**Harnett County**  
420 McKinney Pkwy  
LILLINGTON, NC 27546  
Phone:  
Fax:

**SUBJECT: ERES2303-0002**  
**ELECTRICAL RESIDENTIAL**

Here are the results of all Inspections located at **234 CHEDWORTH DR:**

1 PV SYSTEM ELECTRICAL WIRING SCHEMATIC
SCALE: NTS

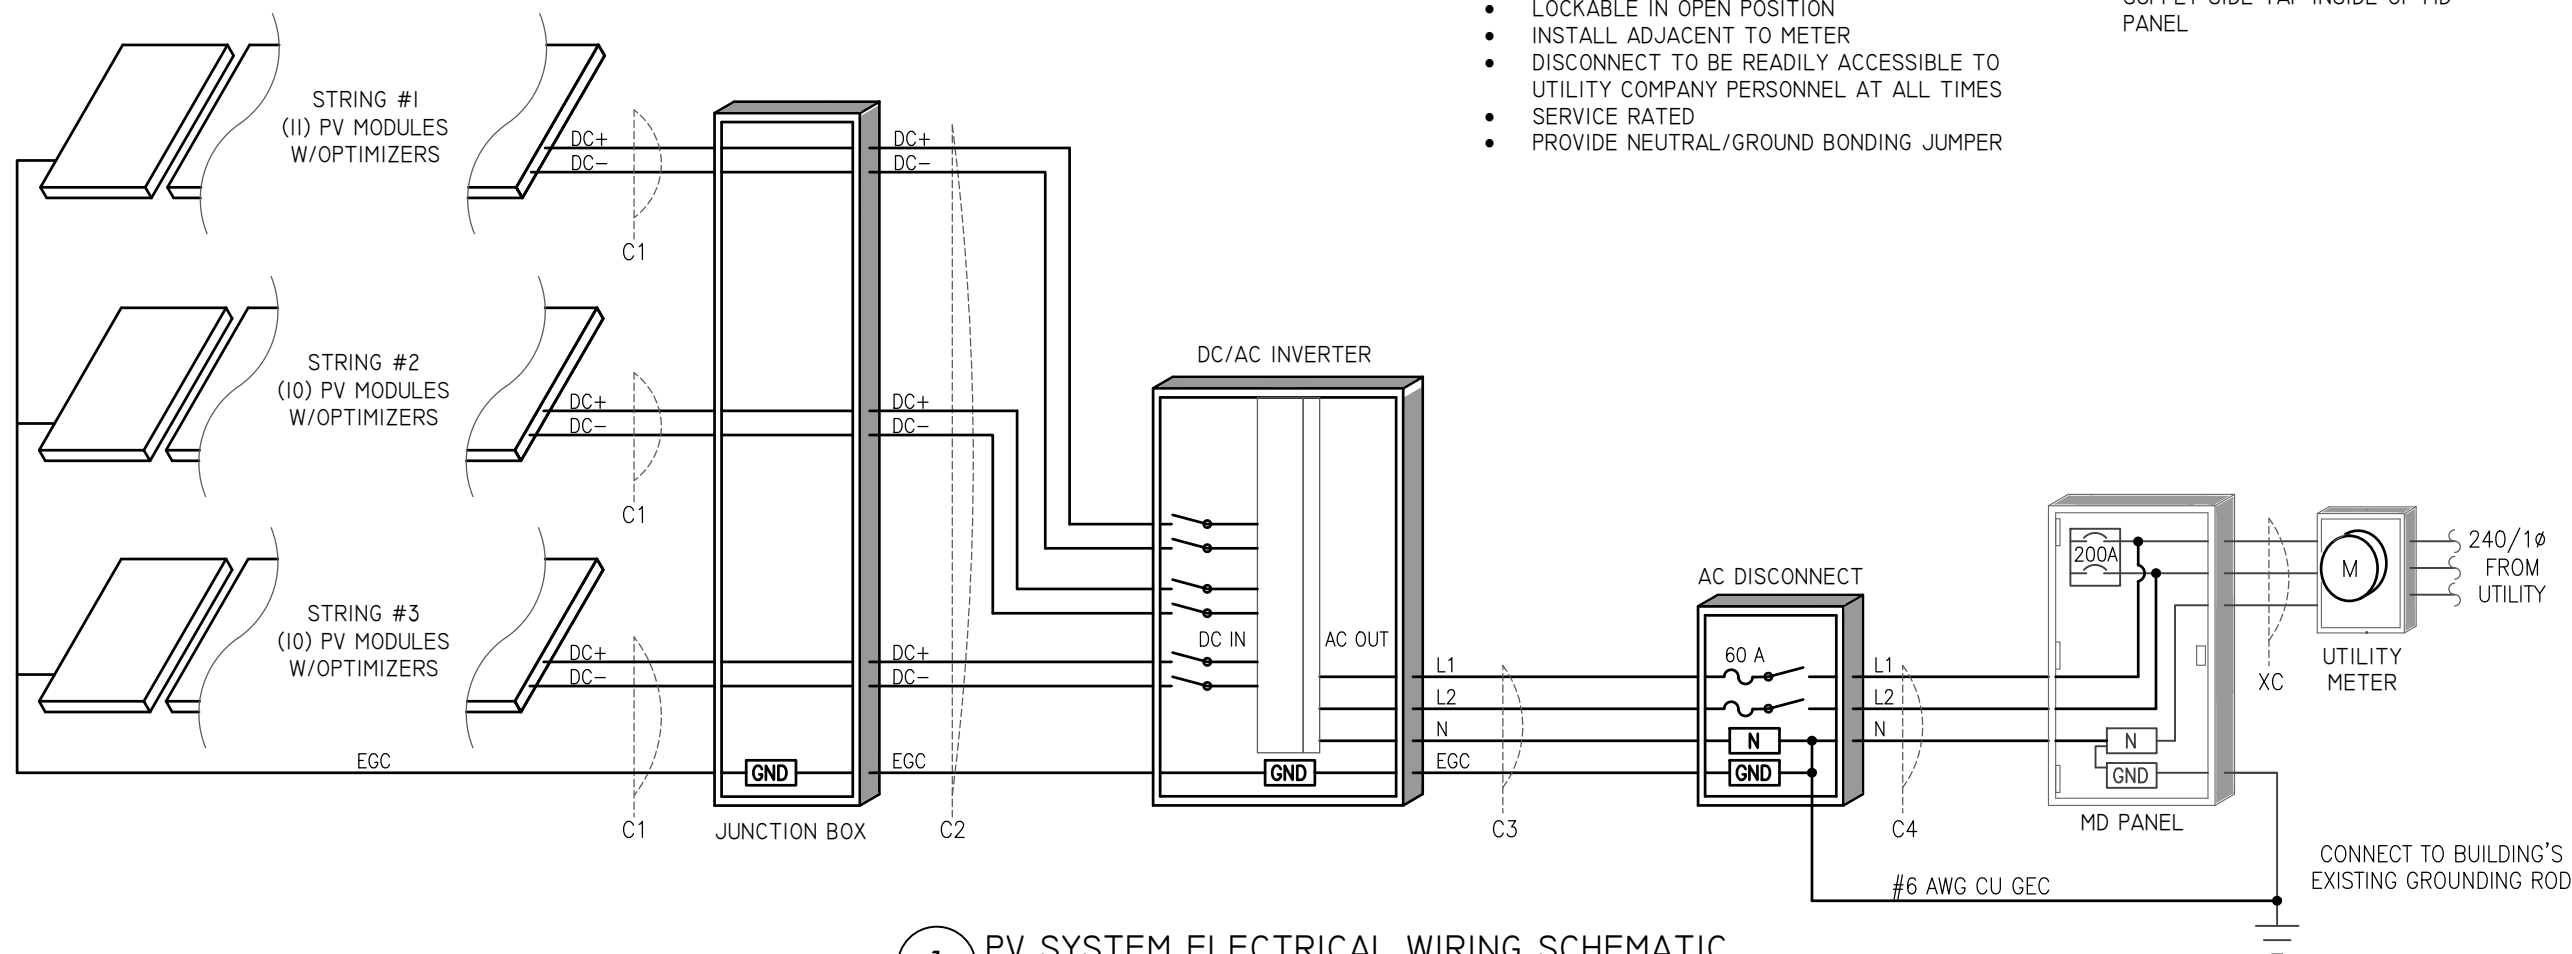
Wrong size breaker on the inverter. Needs 100 amp
